Recommendation Report

Application No. AW/281/11

Erection of a single storey non permanent garden shed (timber) to rear of the property
69 The Fairway Aldwick

Drwg Title:
Proposed
Work

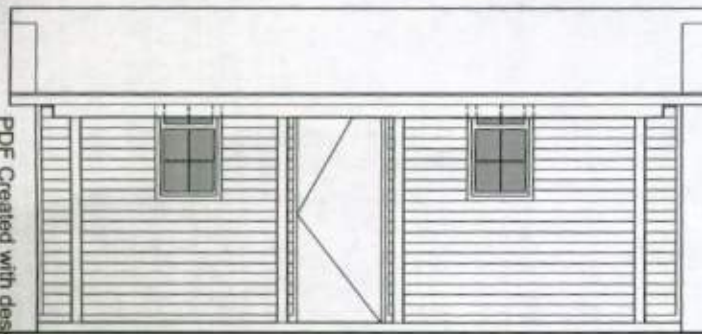
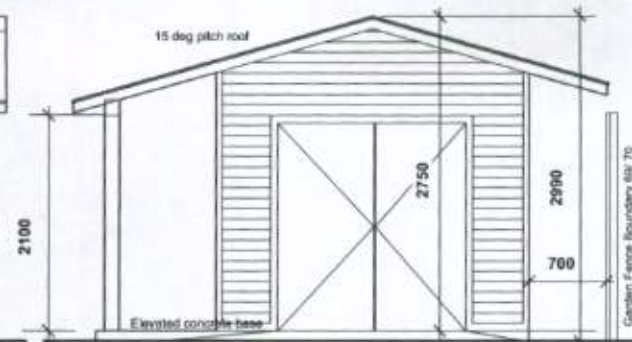
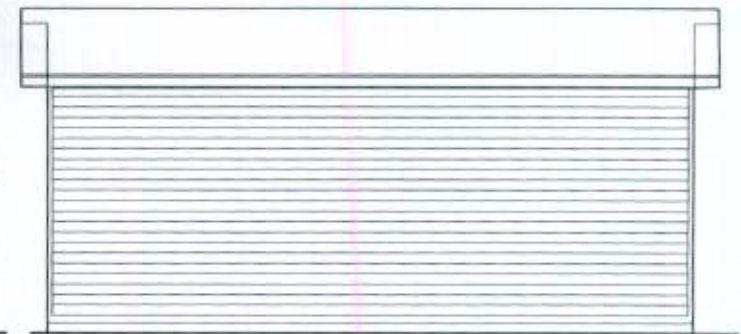
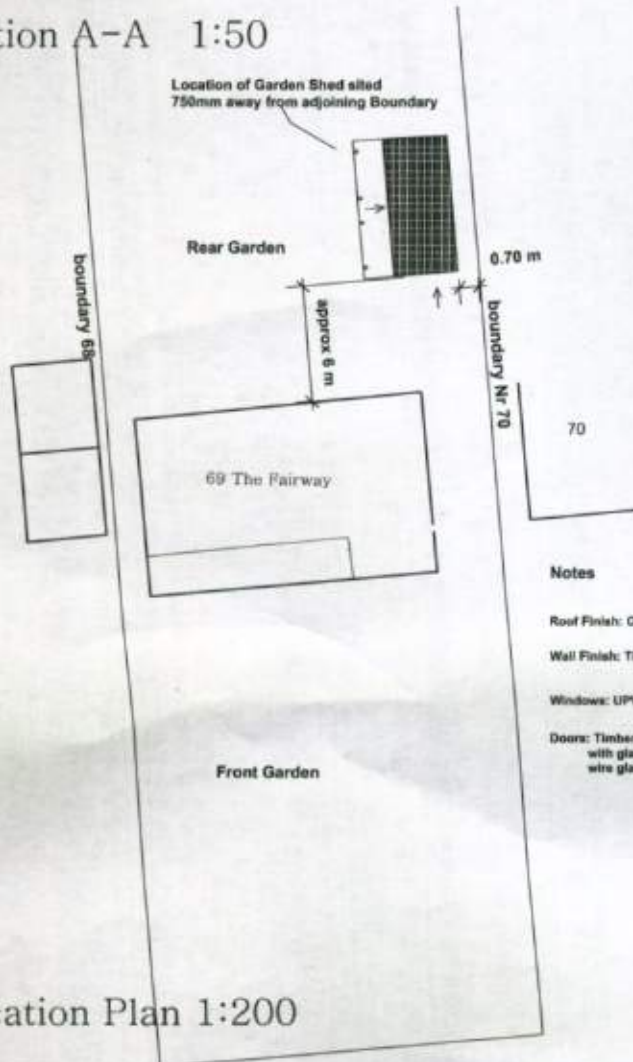
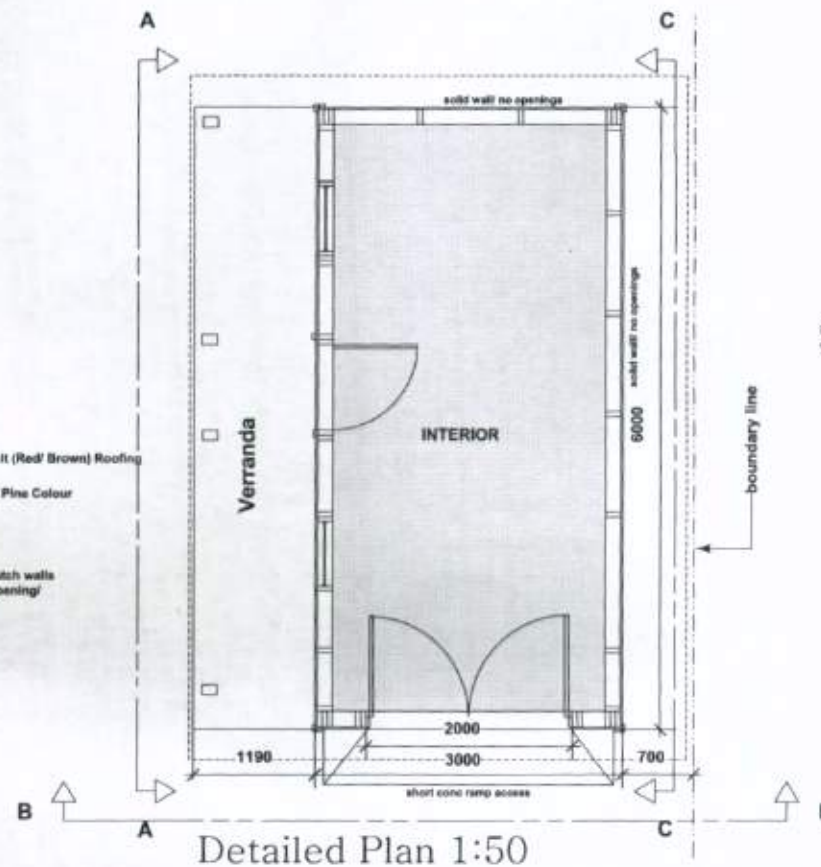
Neighbouring windows: Gd floor patio doors - no. 70 - restricts outlook -
check 45° line

Other: Chalet style detached outbuilding
Timber clad. Shallow pitch roof. Cannot see outbuilding front.
No street scene impact.

Slopy eaves up to side boundary. Close to side boundary.

Both locations - at near boundary in corner.

Members object to this application as it has an unacceptable adverse impact on the adjoining property and does not demonstrate or respond positively to the identified characteristics of the site or enhance the local distinctiveness. Therefore this application is in direct conflict with GEN 7 of the Arun district Local Plan 2003.
